CITY OF ALBUQUERQUE

Re: Ziggis Coffee
5200 Menaul Blvd. NE
30-Day Temporary Certificate of Occupancy
Transportation Development Final Inspection
Engineer's Stamp dated 06-04-21 (H18-D073)
Certification dated 08-30-22

**RE: Traffic Certification for Ziggis Coffee at 5200 Menaul Blvd. NE (BP-2022-14172)
(Original permit # BP-2021-25150)**

AL SITE PLAN

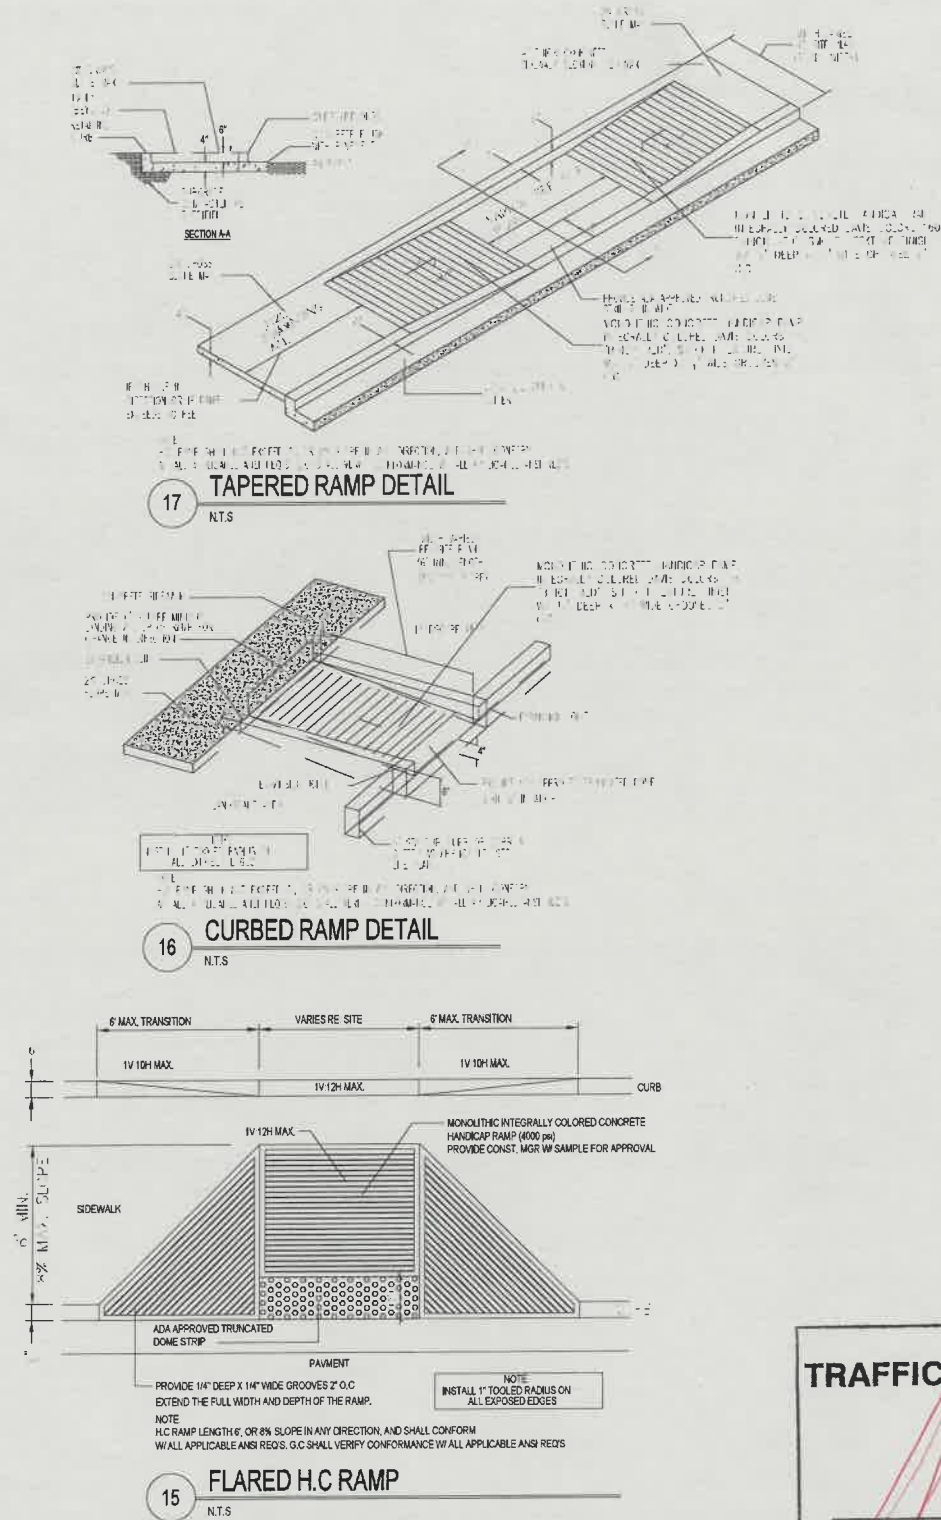
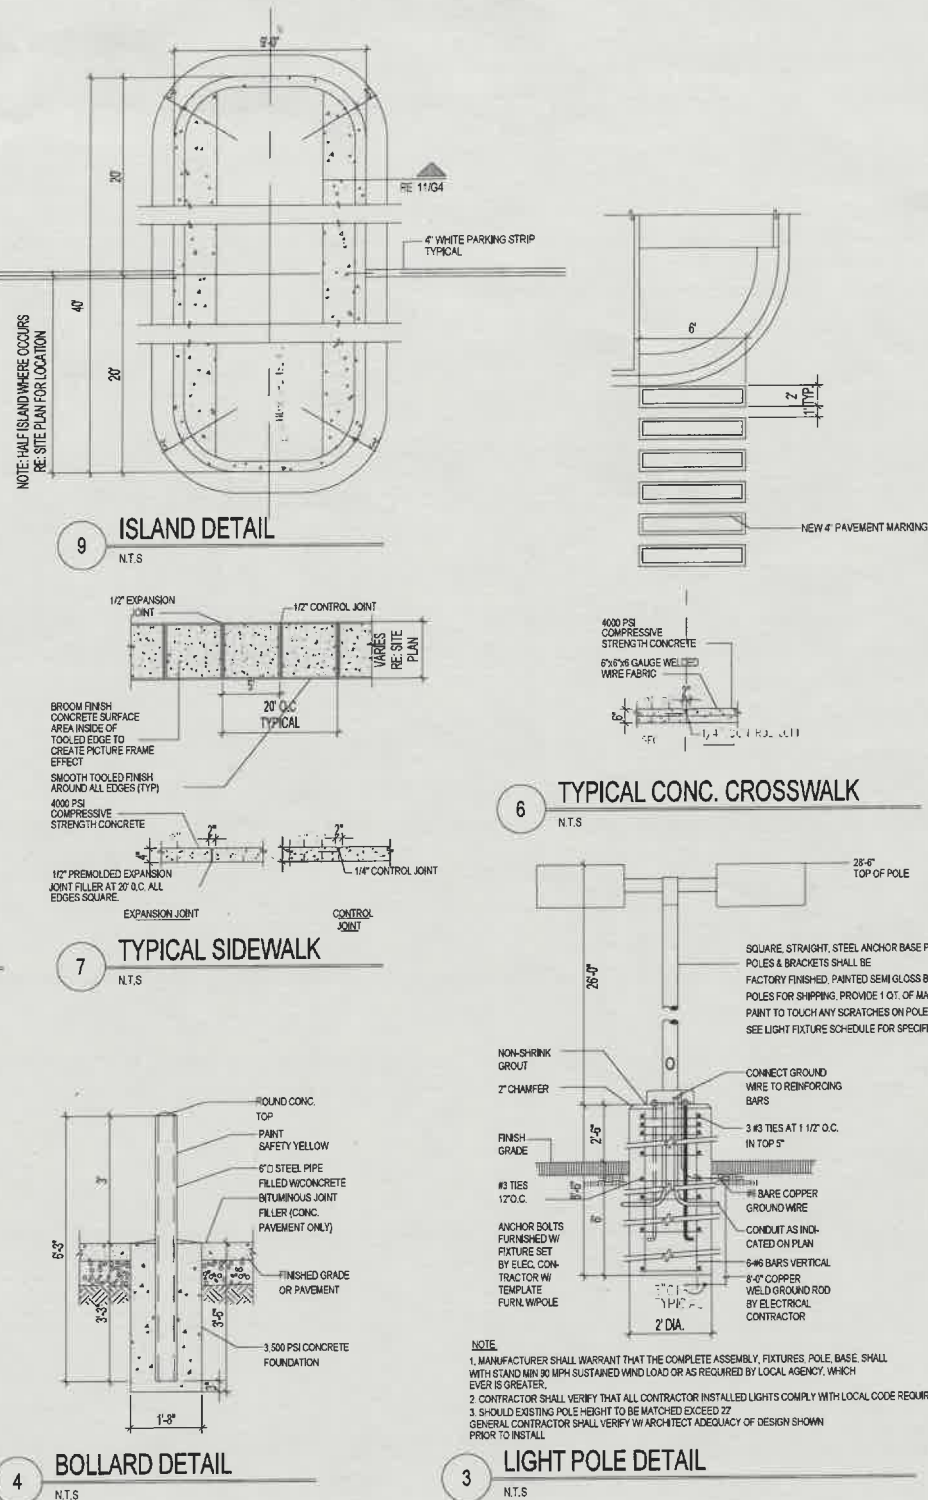
- Provide As Built site plan, and red mark the following changes:
 1. Per site visit, the dimension from the ADA ramp (at the north of the building) to the building are 4'.
 2. Per site visit, the location of the Bike Rack is on the northeast side of the building (on the Patio area).
- "Drive-Thru" pavement marking is missing.
- Please provide "Drive-Thru" signs at the beginning of drive-thru lanes.
